RFI

RFI #: 89
Date: 2/29/2012
Job: EB-02 Keller Springs Lots
Phone: 877-777-5115

Subject: Sidewalk elevations missing south of Addison Approach

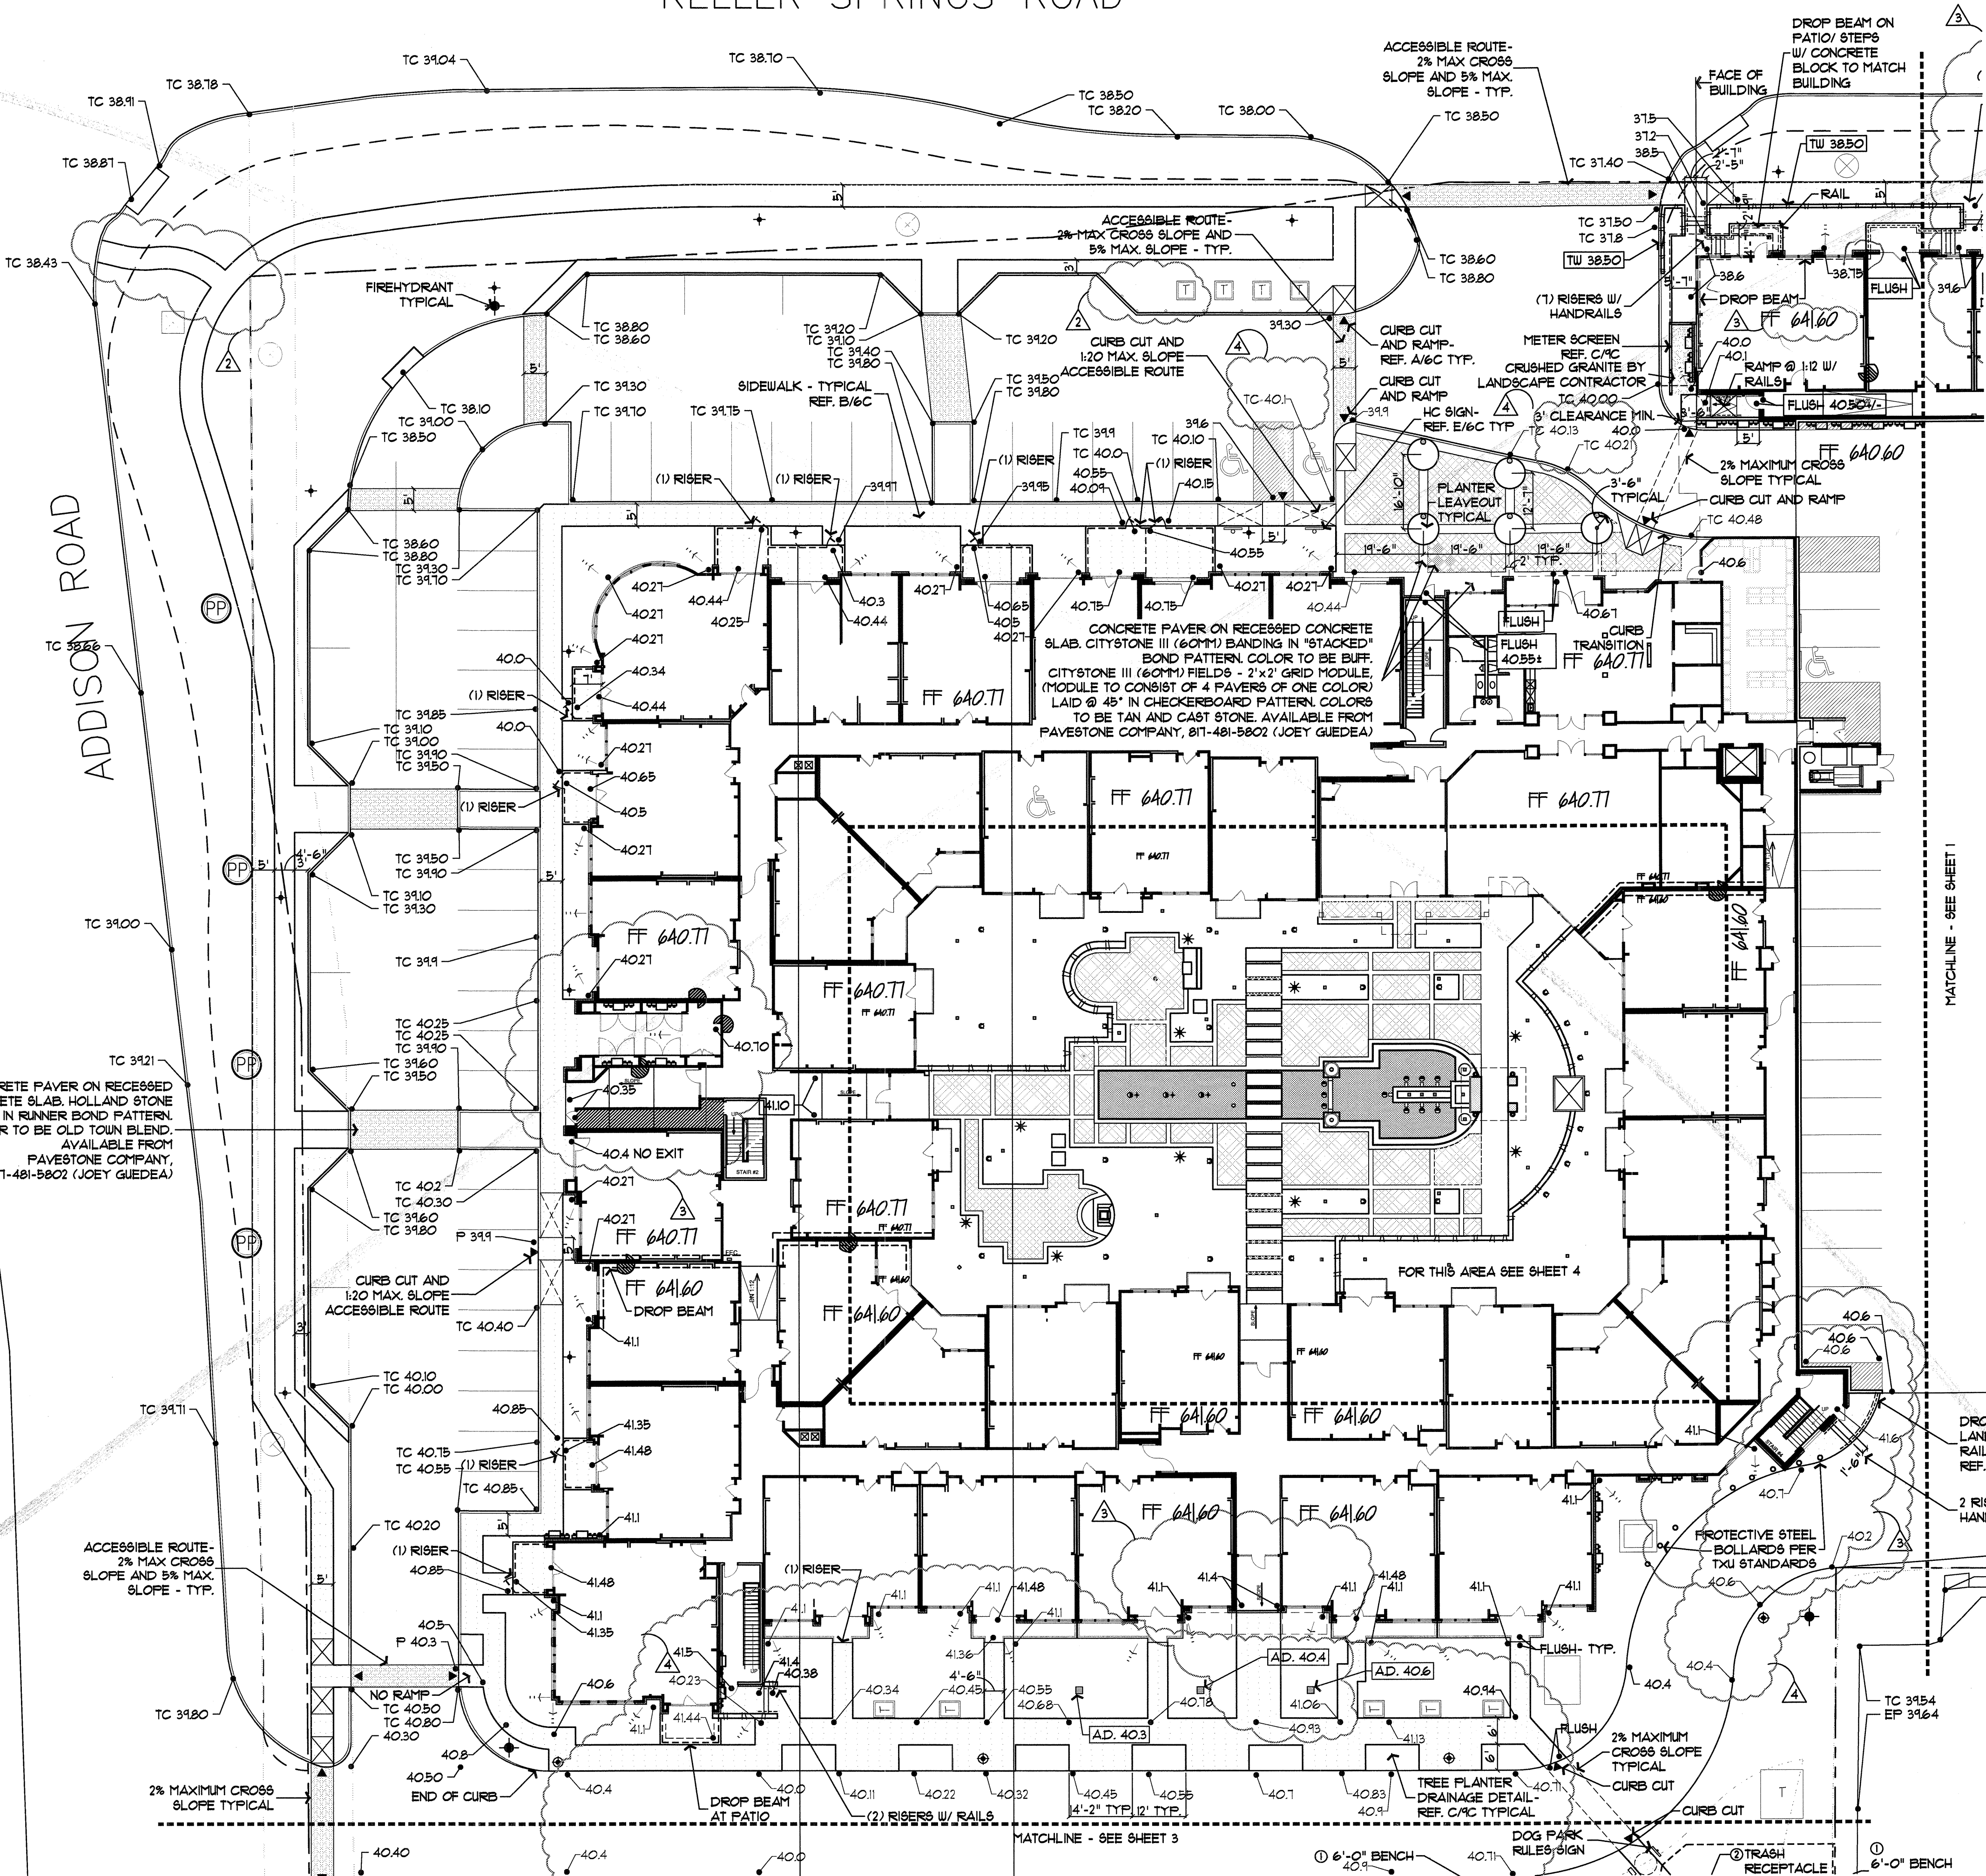
Request: Date Required: 3/1/2012
We have removed the existing city sidewalk and staked new location of sidewalk south of Addison Approach. I have no elevations. Can you give me some as city wants that side walk poured by end of day on Friday. See attachments for clarification.

Response:
Please see attachment with grades
